Consultation Response from KC Highways Development Management		
2026/90620 Central Warehouse, Bradford Road, Batley, WF17 5LW		
Demolition of existing building and erection of food/drink building with drive thru lane (Class E)		
Date Responded: 25/08/26	Responding Officer: M Zenner	Responding Ref: 13-10SE/9

RECOMMENDATION: HDM considers that whilst additional information has been provided it is not sufficient to overcome highways concerns in relation to the proposals and to comply with NPPF TR6.

Proposed Site Layout - Scale 1/500

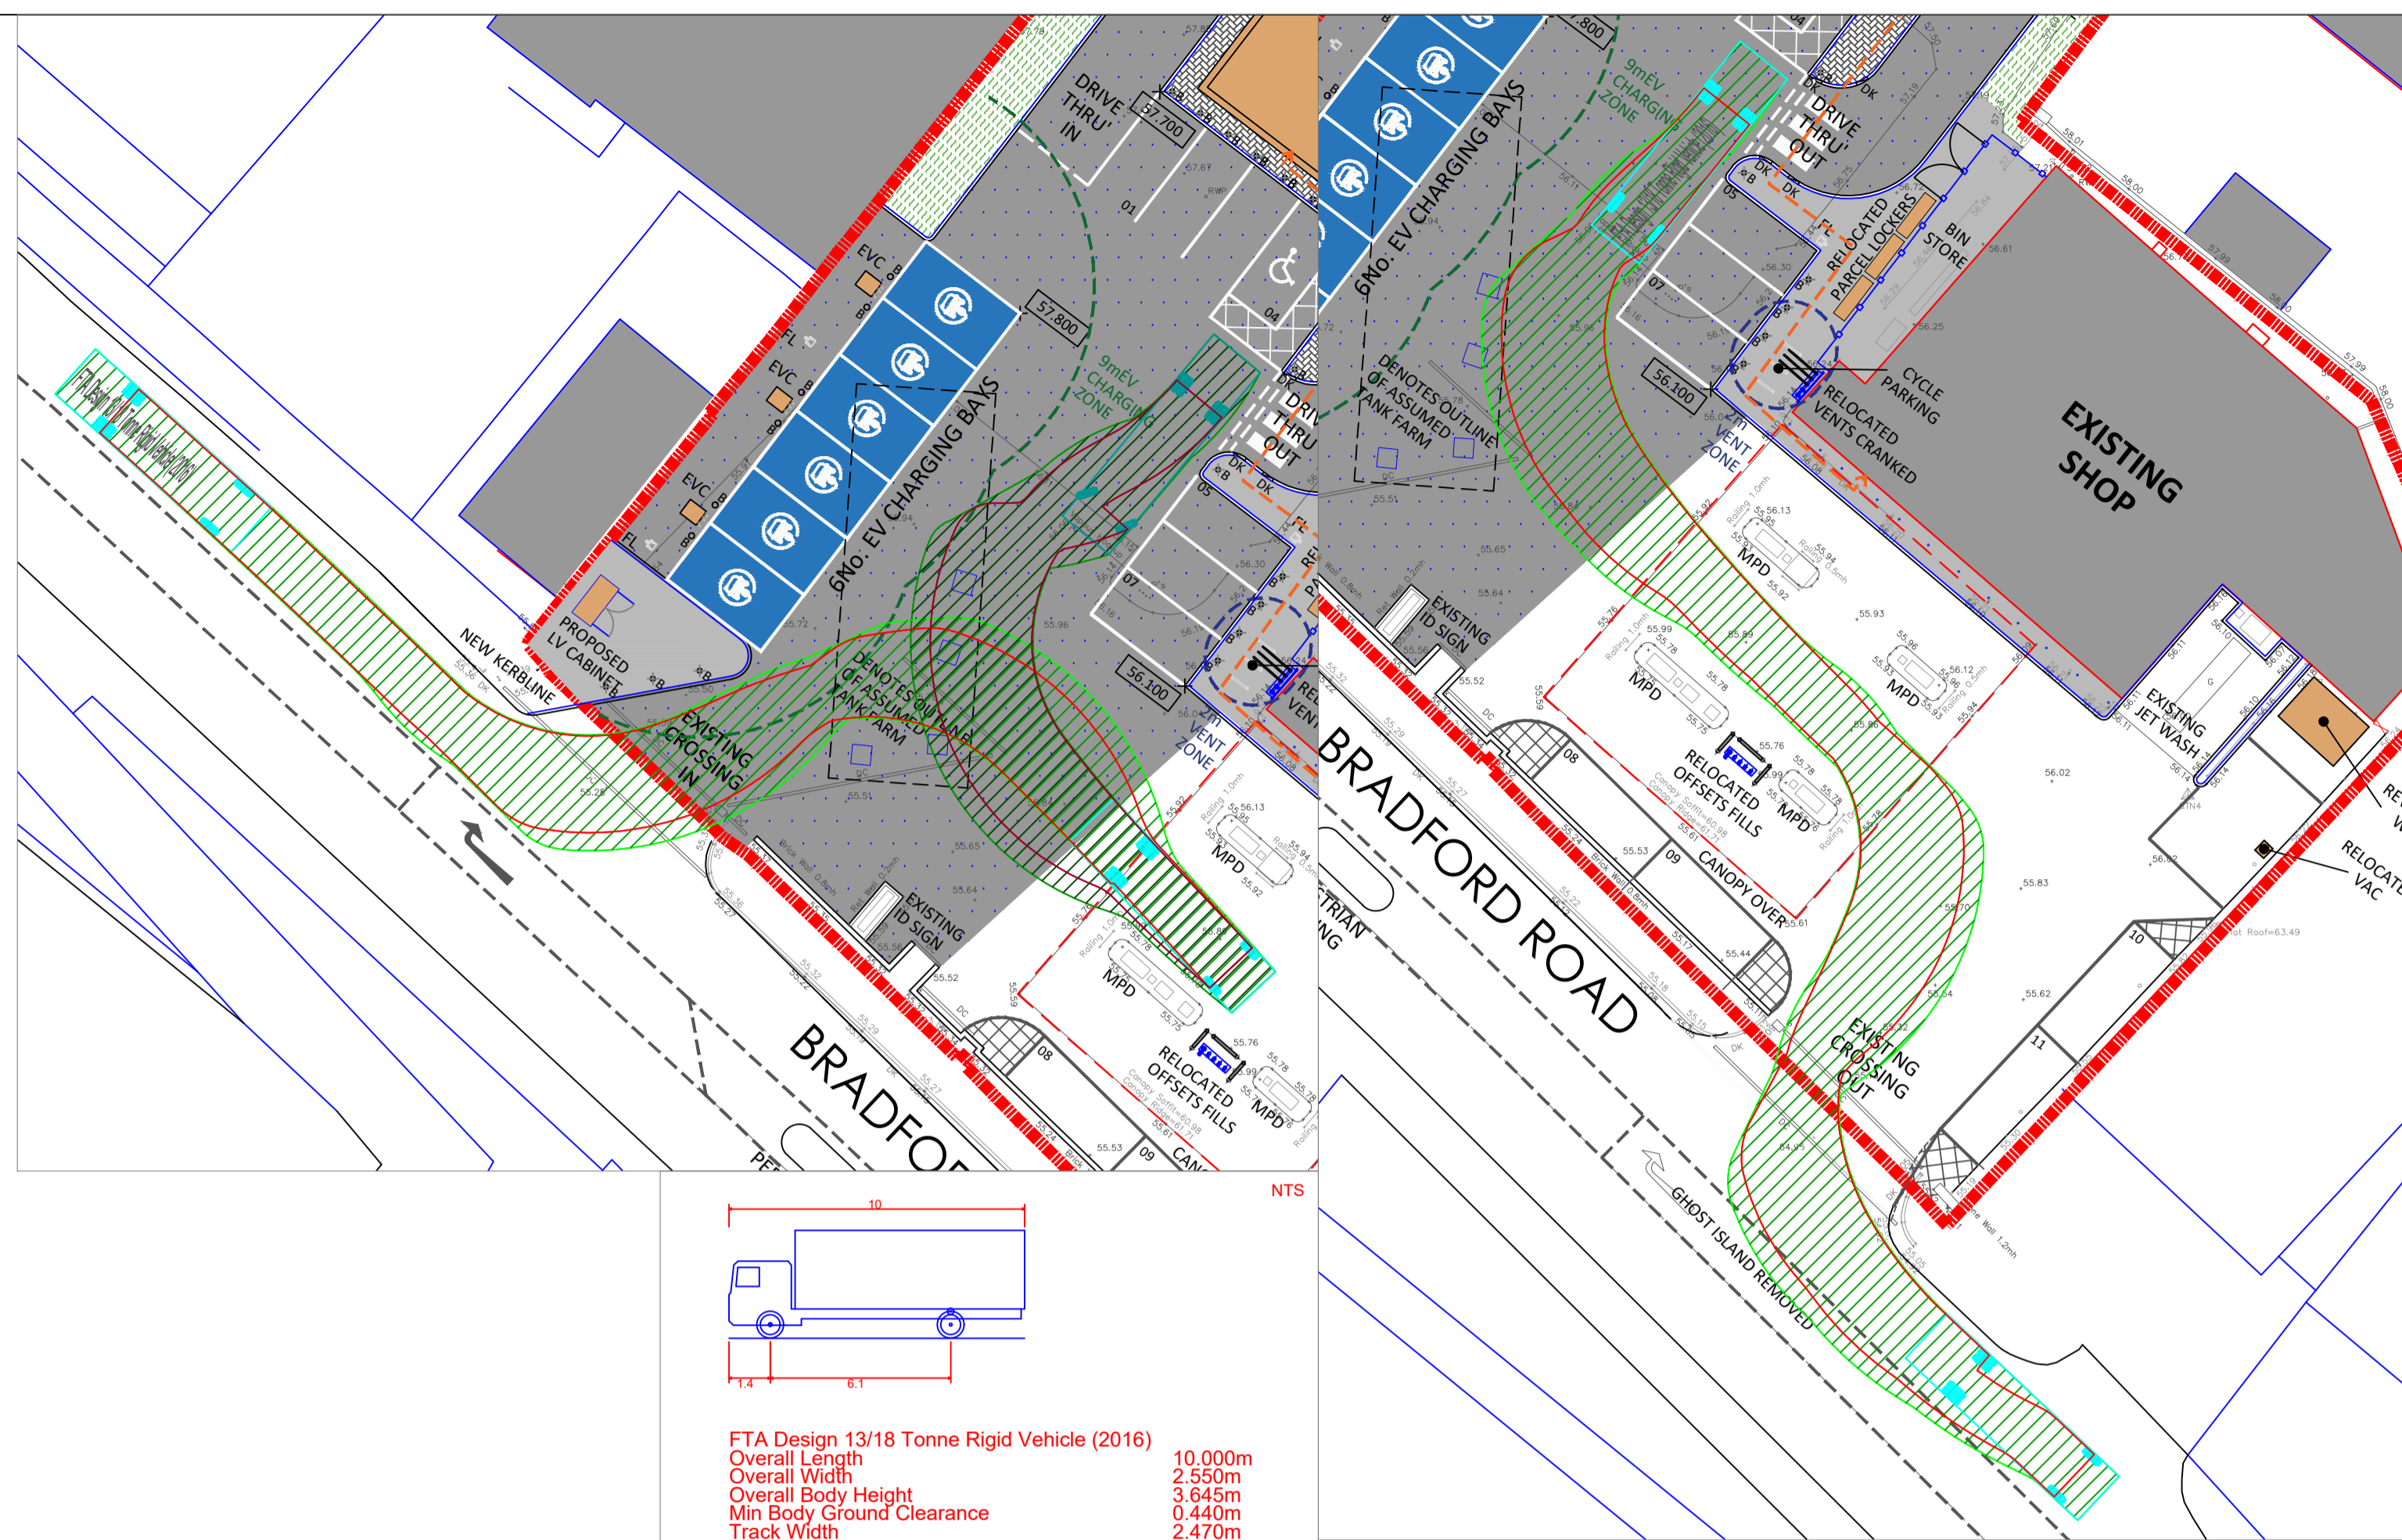
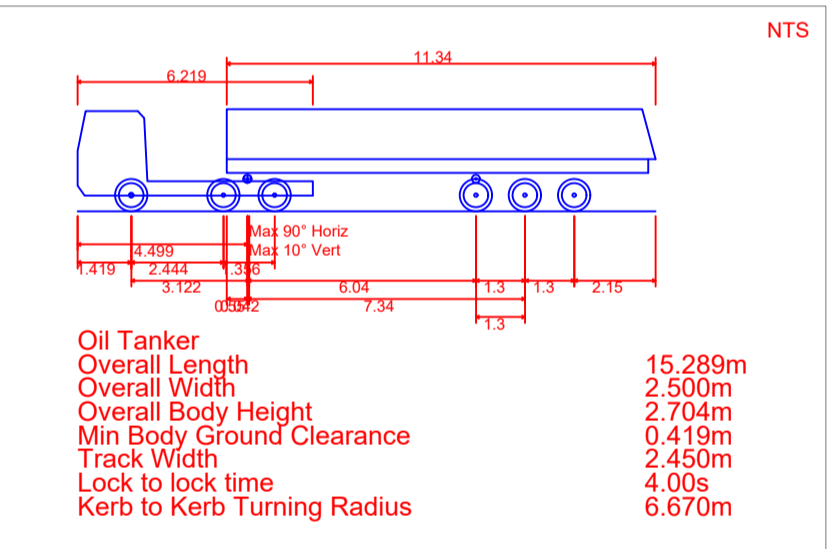
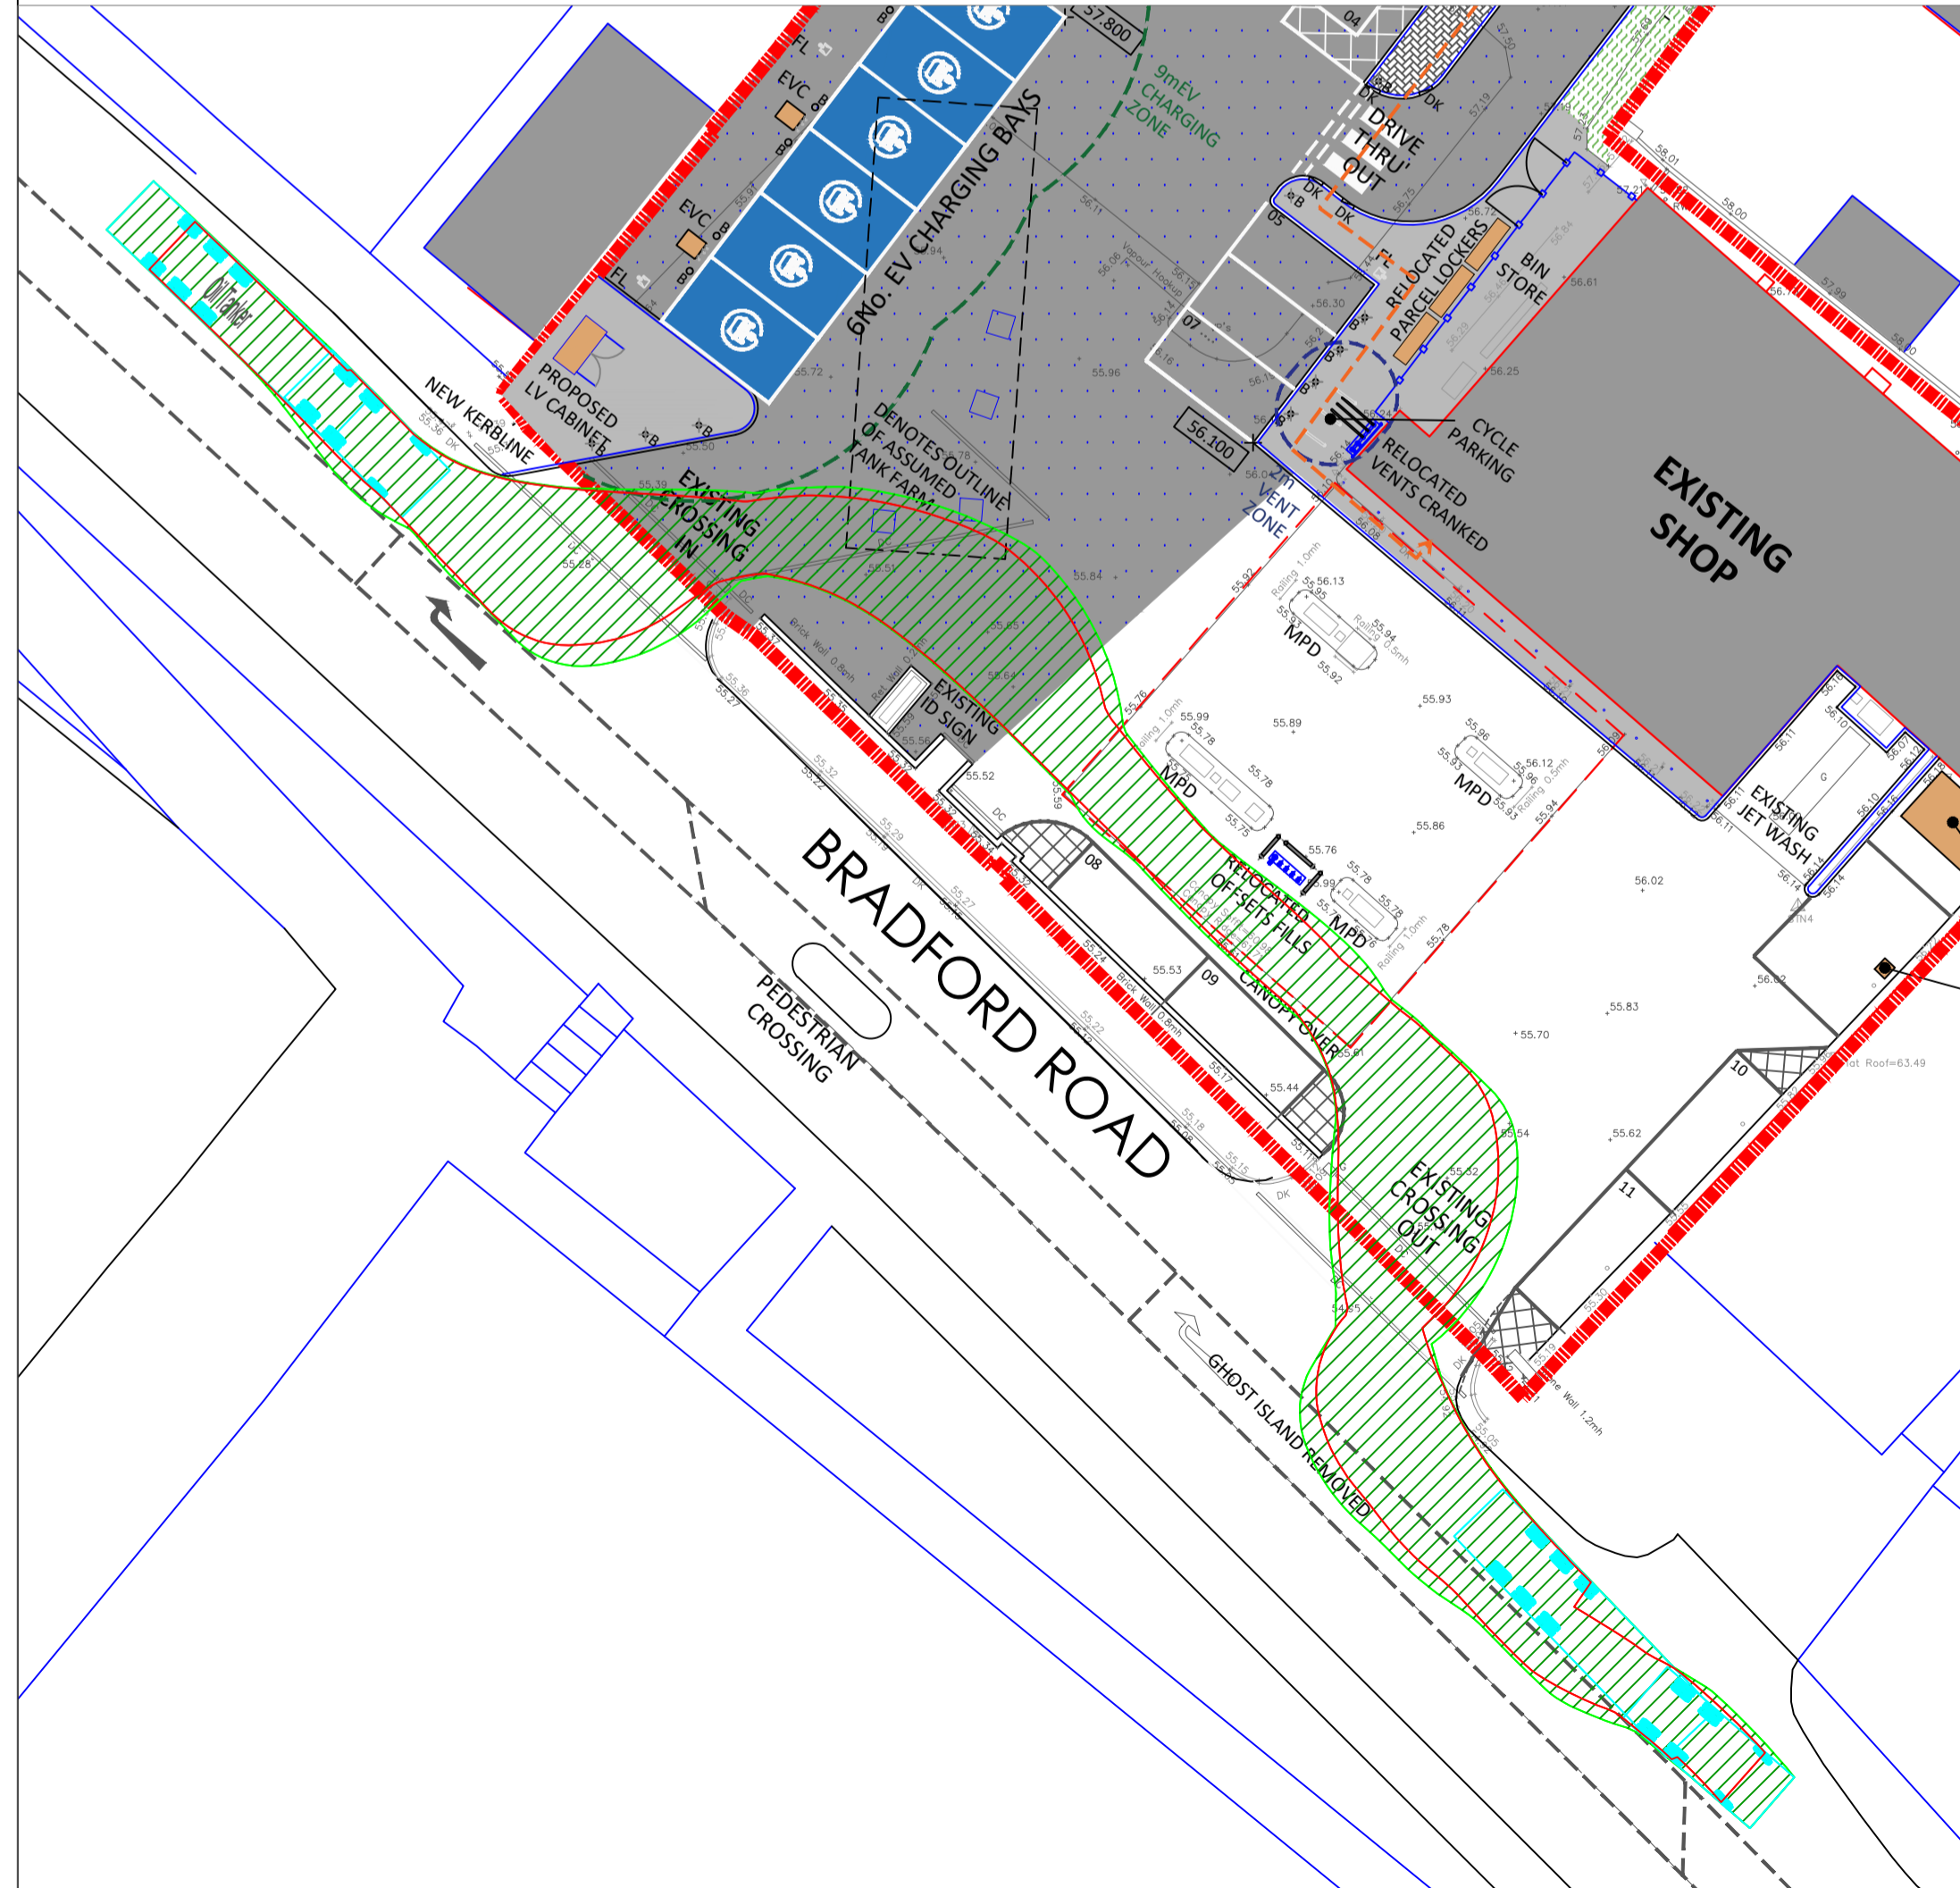
HDM previously requested swept paths to be provided for the site. Dynamic Transport Planning have provided swept paths for the largest vehicles they deem will service or access the facilities. They have detailed a large car accessing / egressing part of the drive thru lane, but do not show vehicles negotiating the tight alignment on the approach and exit from the drive thru lane; which is required. Furthermore, large vans are likely to use the drive thru and therefore larger vehicles should have been shown accessing the full route into and out of the site and the drive thru lane also.

The swept paths provided also show the oil tanker servicing the site using the relocated offsets fills which have been relocated to in-between the pumps. The vehicles accessing via the western access on Bradford Road appear to track exceptionally close to the proposed kerblines and may cause damage on part of the public highway. 0.5m clearance to kerbing or vertical obstructions on each side of the swept path should be provided. Designs should therefore, where possible, aim to cater for vehicles larger than the above minimum standards.

A swept path has been provided for a 10m rigid which appears to service the drive thru unit, but it accesses by driving towards the pumps and reversing back towards the accessible bay, which could cause conflicts within the site as this occurs in close proximity to the pedestrian path indicated within the site, furthermore the vehicle would block egress from the drive thru lane and impede vehicles intending to access the drive thru lane, plus it may impede vehicles intending to exit parking spaces 1-7 plus several of the EV charging bays. To exit the site the vehicle would need to exit through the pumps and would require the central four pumps to be clear of vehicles to have adequate space to exit. HDM is concerned that this could cause queuing and obstruction within the site which could cause queuing back onto the public highway.

It is noted that an RSA brief has been submitted by Dynamic Transport Planning, however, at this stage HDM cannot support the arrangements due to the potential for queuing and obstruction at the access to the site and the issue with the oil tanker swept path detailed above.

HDM is concerned that this arrangement appears very tight for vehicles manoeuvring in and out of the site due to the presence of the EV charging spaces and proposed car parking spaces within the site, the swept path proposed only shows vehicles on the loop itself not accessing and egressing the drive thru lanes.
